Application No: M/98/25/HH
Site Address: 1 Elmer Court Elmer Middleton-on-sea PO22 6JT
Description of works: Extension and alterations to form a rear facing balcony and sliding doors (part retrospective).

Thank you for your internet representation made on 16th January 2026 which has been recorded as an objection with the comments as follows:

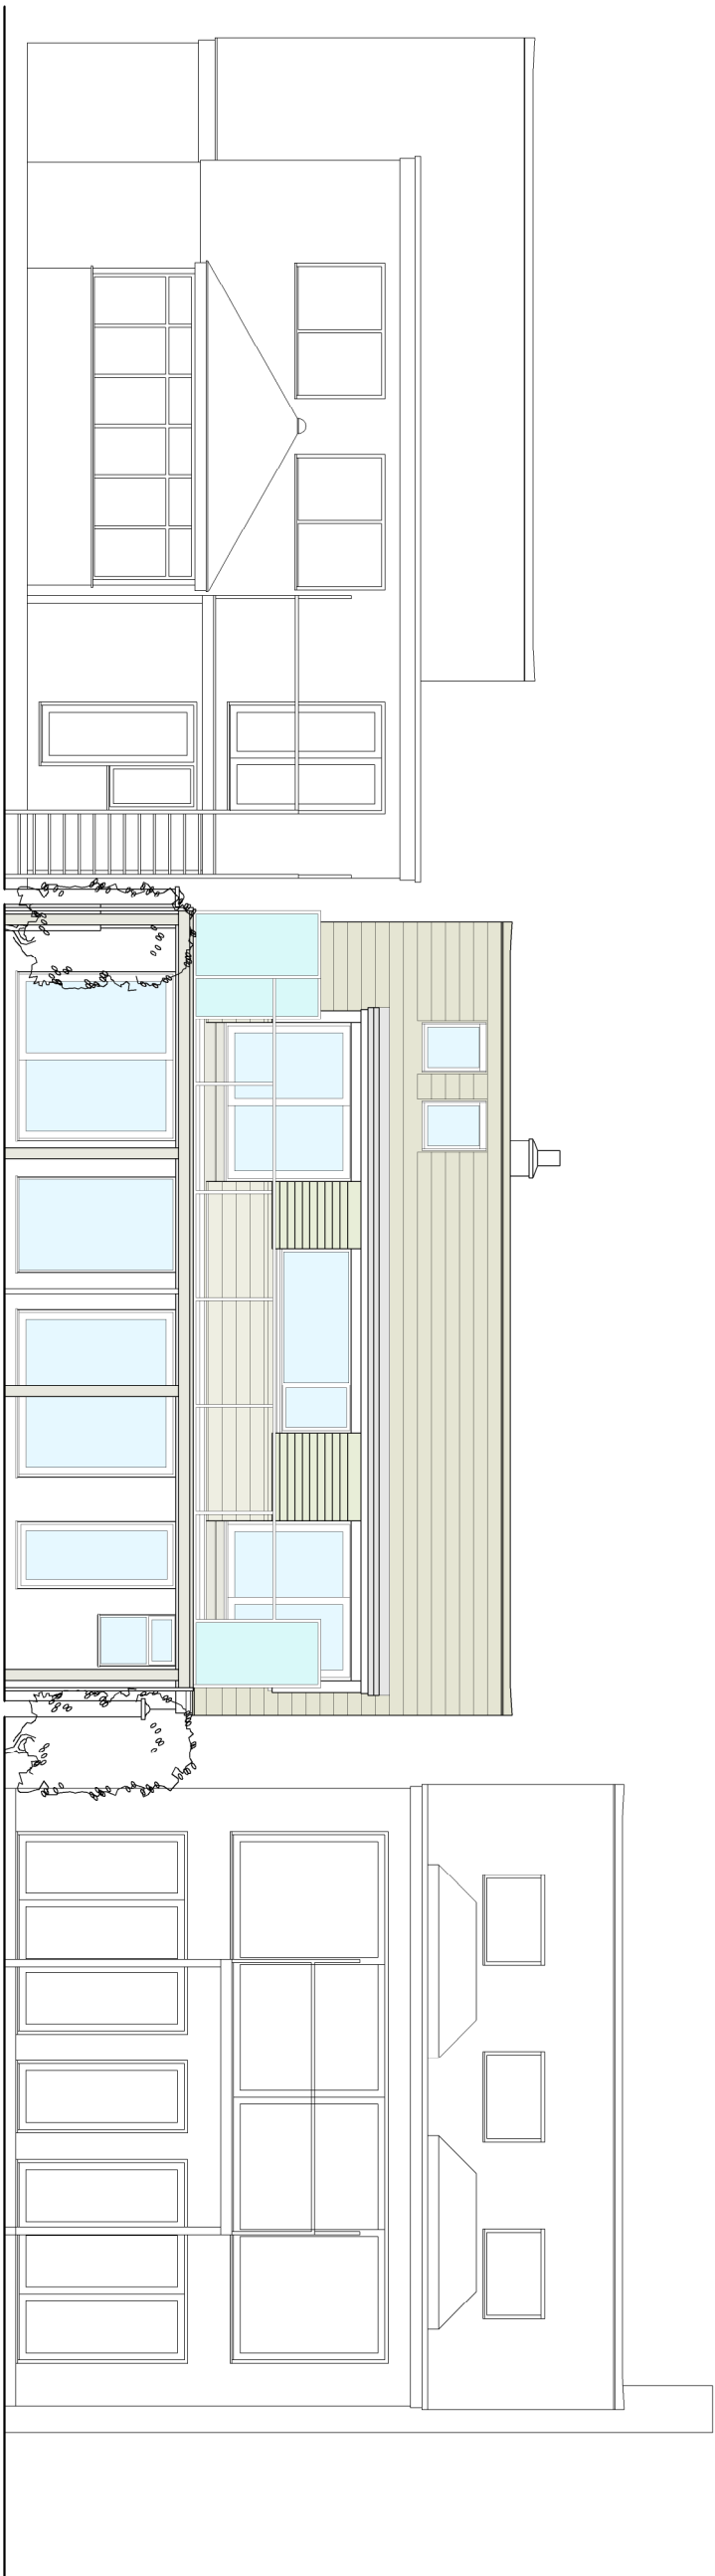
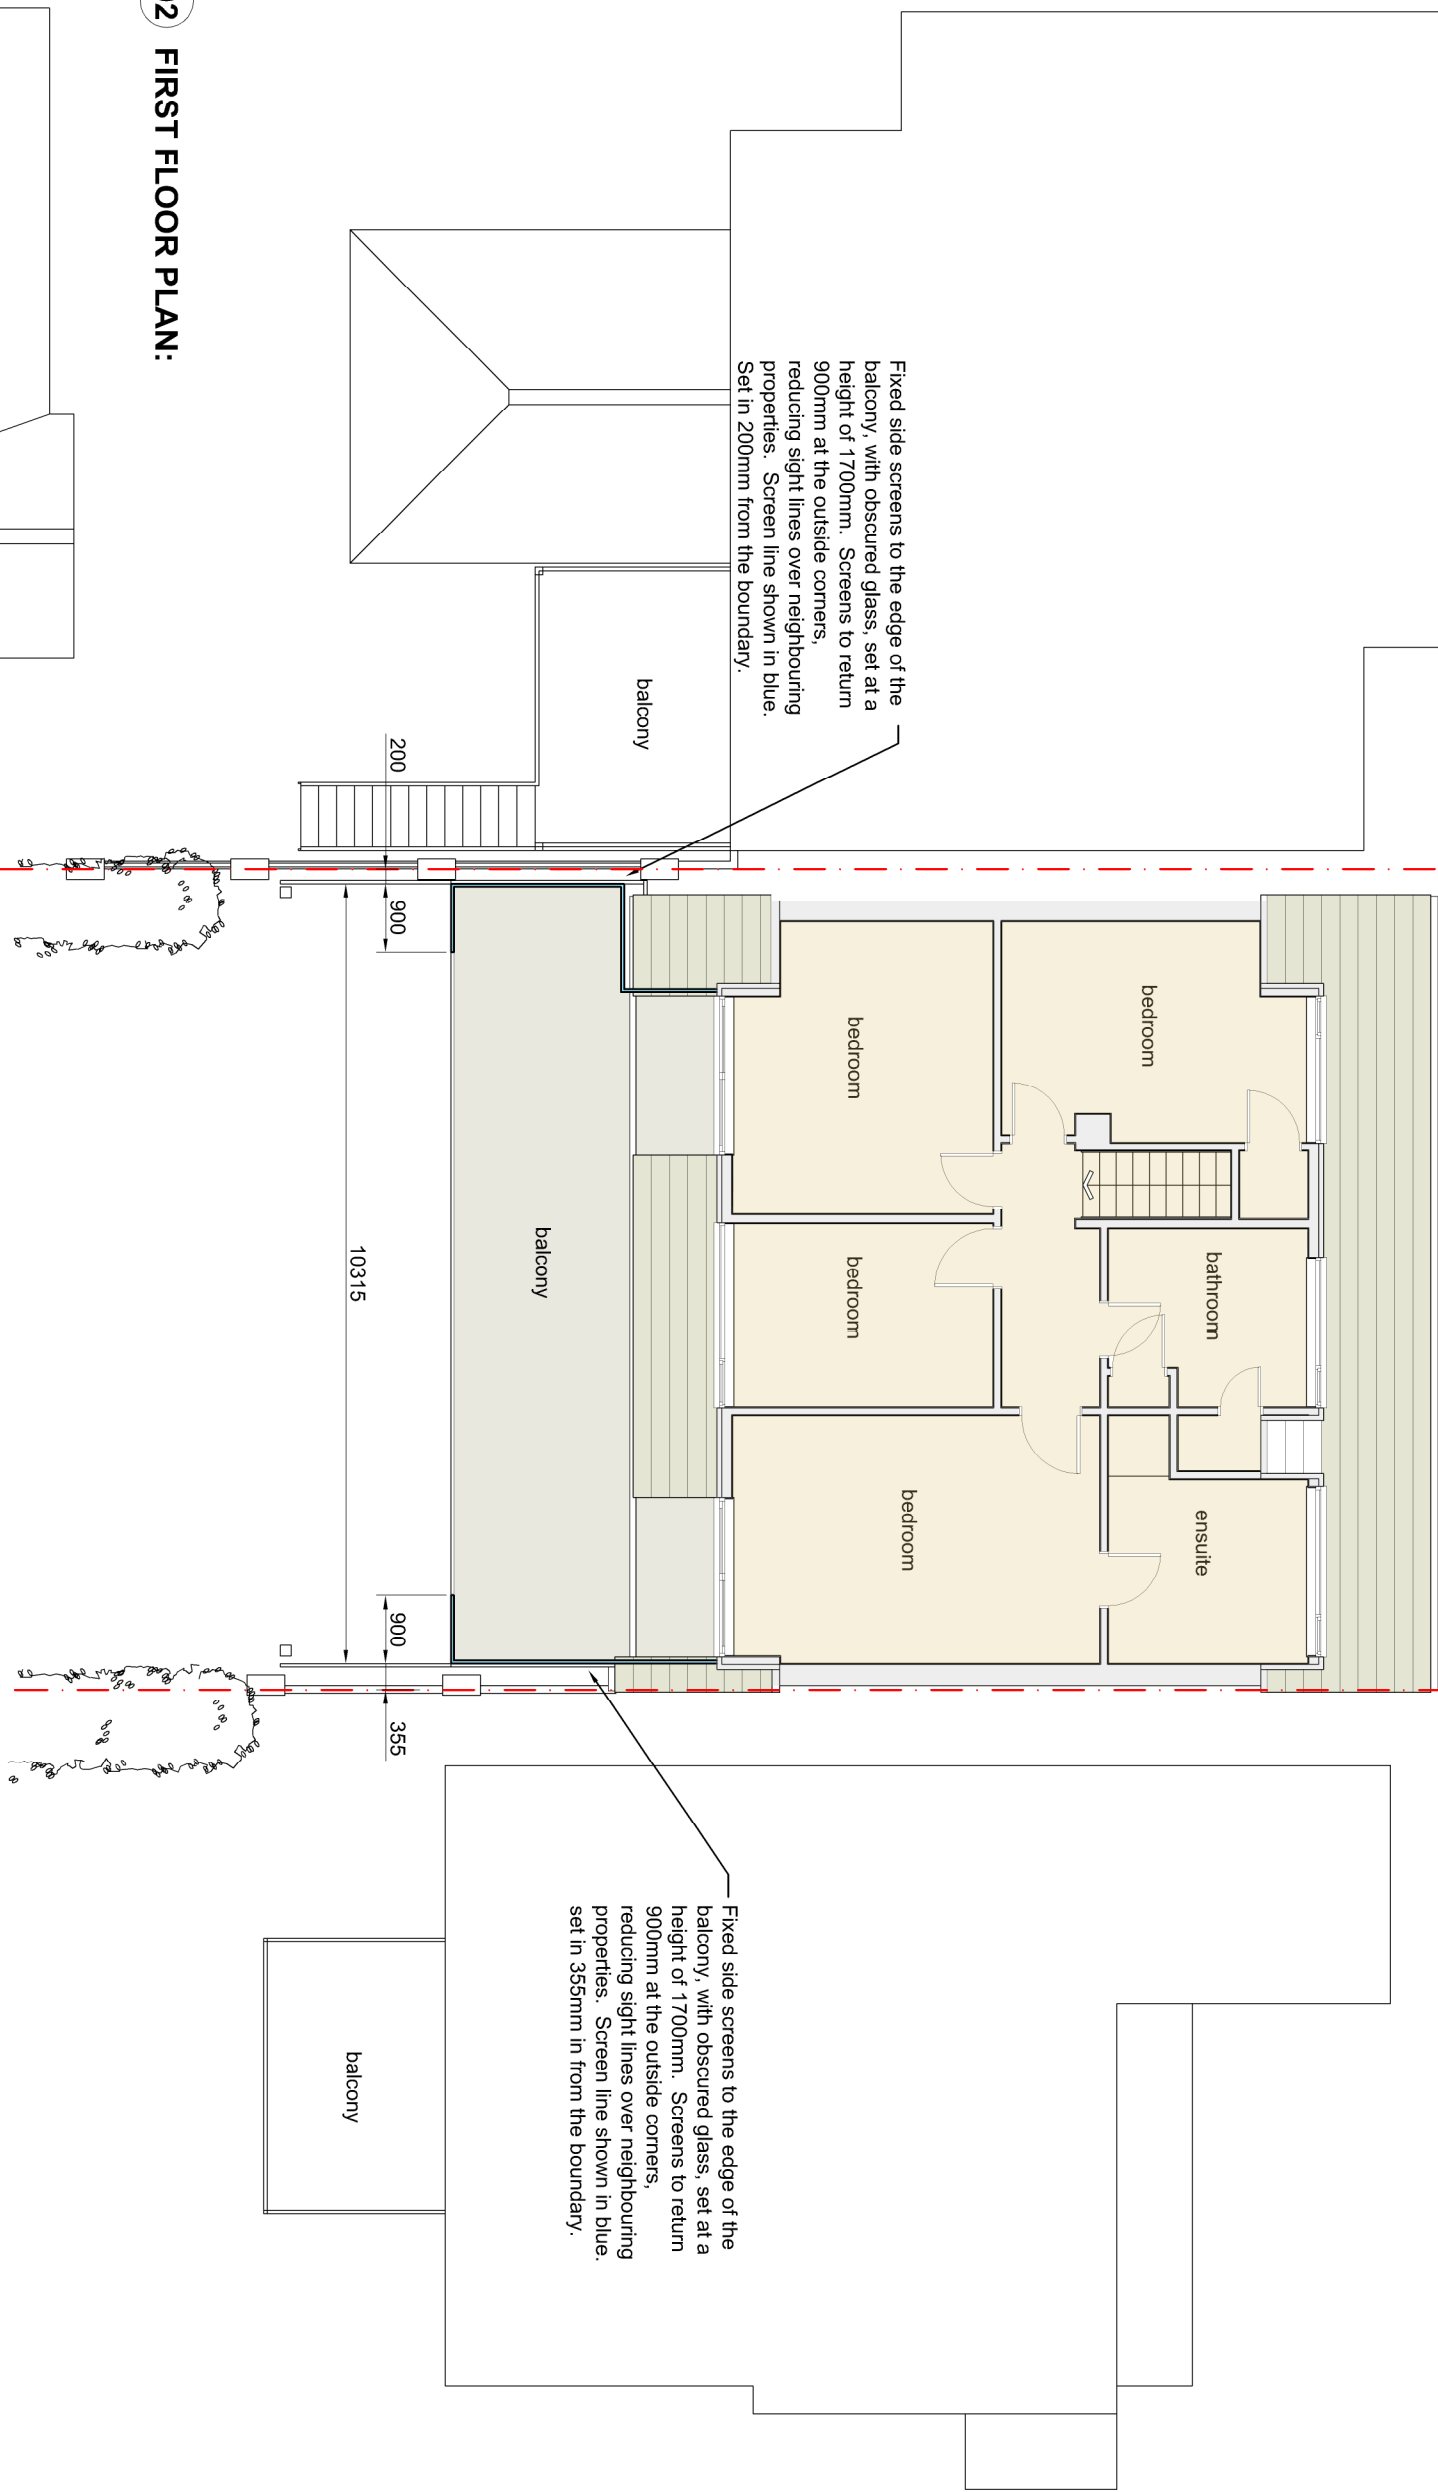
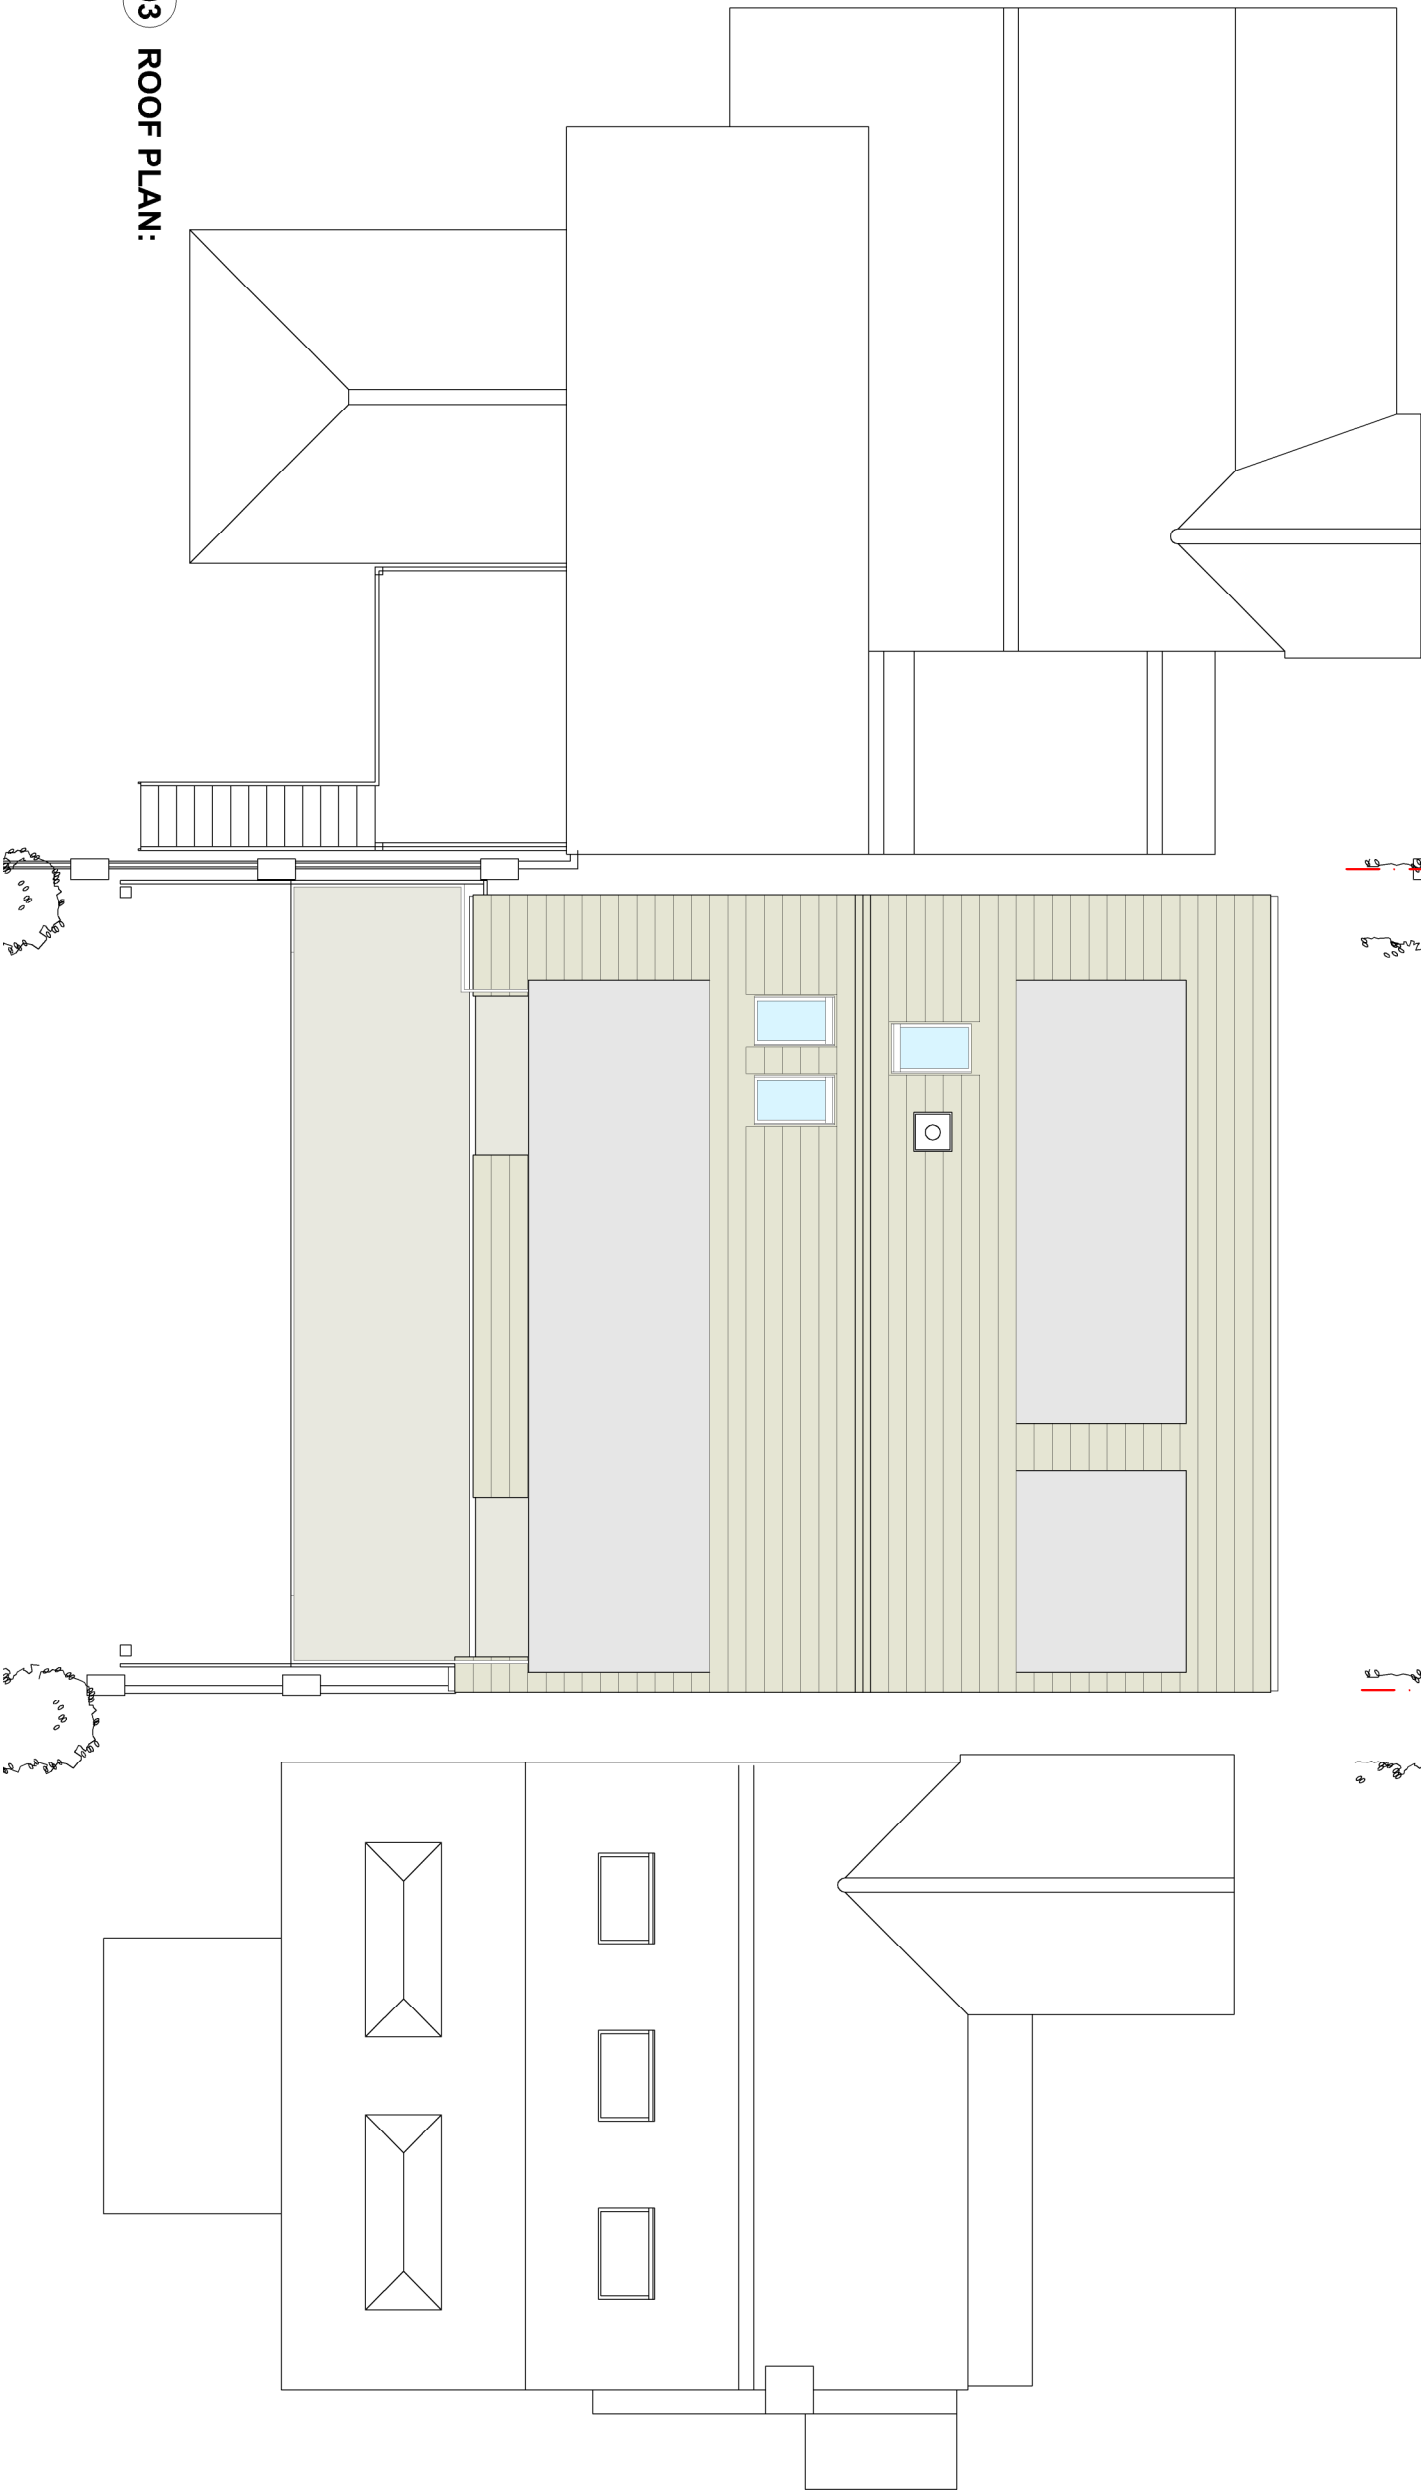
It will still be an overbearing structure as it has been built up to each of the neighbours boundaries meaning both properties will suffer from lack of privacy, overlooking and noise disturbance from any occupants on the balcony.
